Subject: Ranch Road Performance Based Cluster Plat (LPF-19-00002) Final Plat. – Staff Review and 2nd Request for Additional Information

TO: All Staff
FROM: Justin Turnbull, County Surveyor 
DATE: April 3, 2019
SUBJECT: County Survey Review of Final Plat LPF-19-0002 (Ranch Rd Final Cluster Plat)

RANCH ROAD CLUSTER PLAT P-07-38

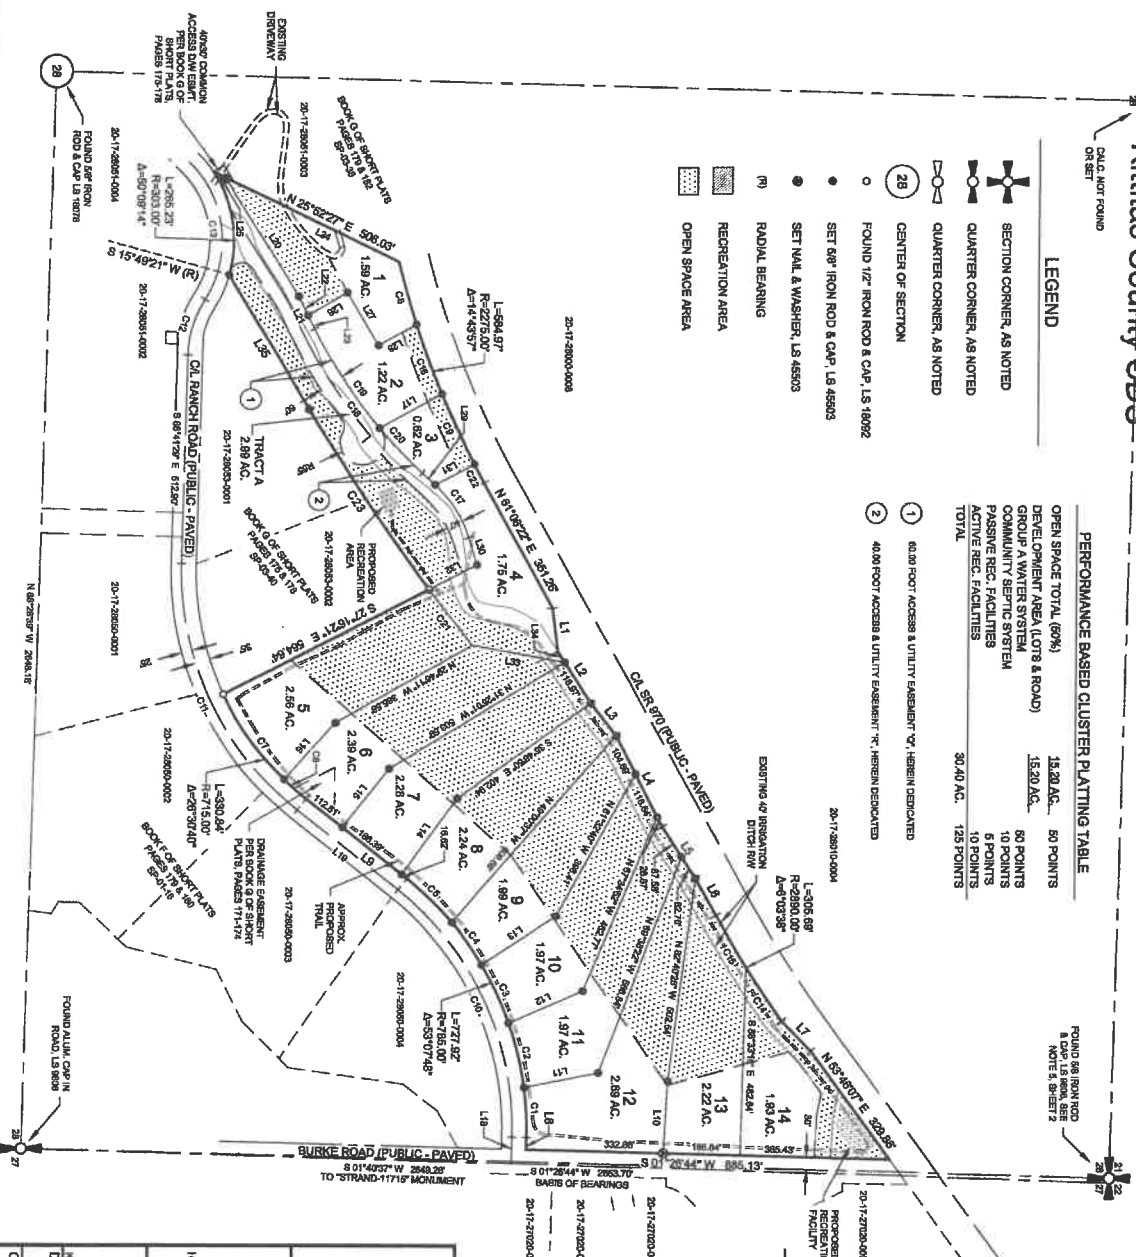
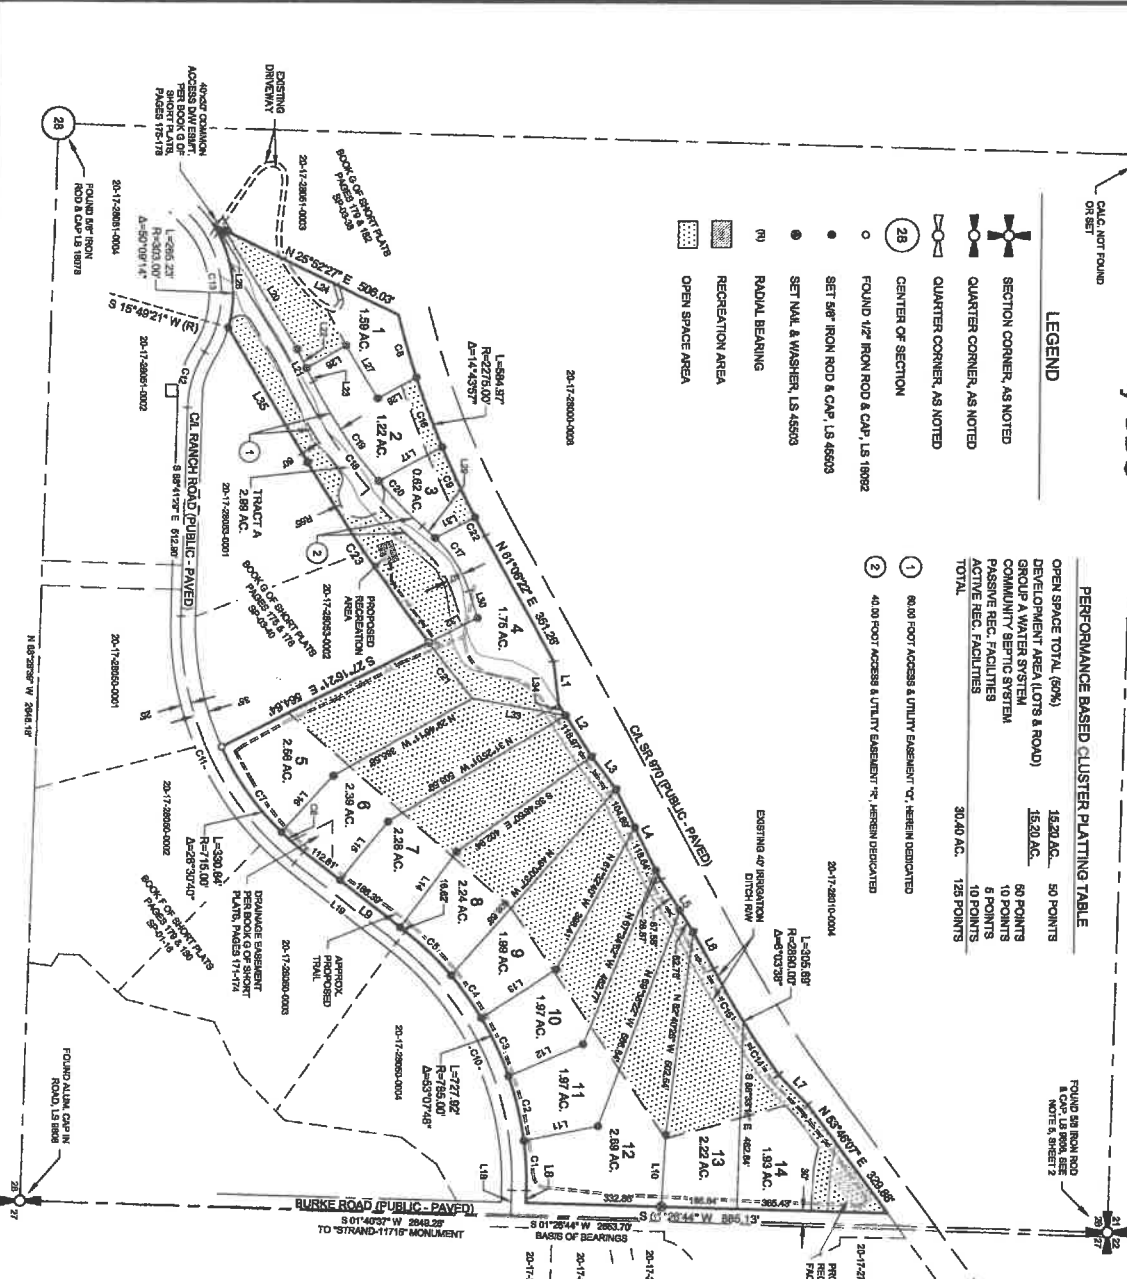
- 1) The requested changes from the previous request for additional information letter dated March 25, 2019 and the Public Works Memo dated March 20, 2019 have all been met except for item 3.
"3. The ownership of public right of way should be clarified as being county or state.
EX: "Burke Rd – County R/W – Paved""

- 3. The ownership of public right of way should be clarified as being county or state.
EX: "Burke Rd – County R/W – Paved"*

This should be shown for all roadways including state and county owned right of way.

The portion of the Old Sunset Highway North of the bend of Burke road may be labeled just as county right of way, as there is no official road designation for this portion.
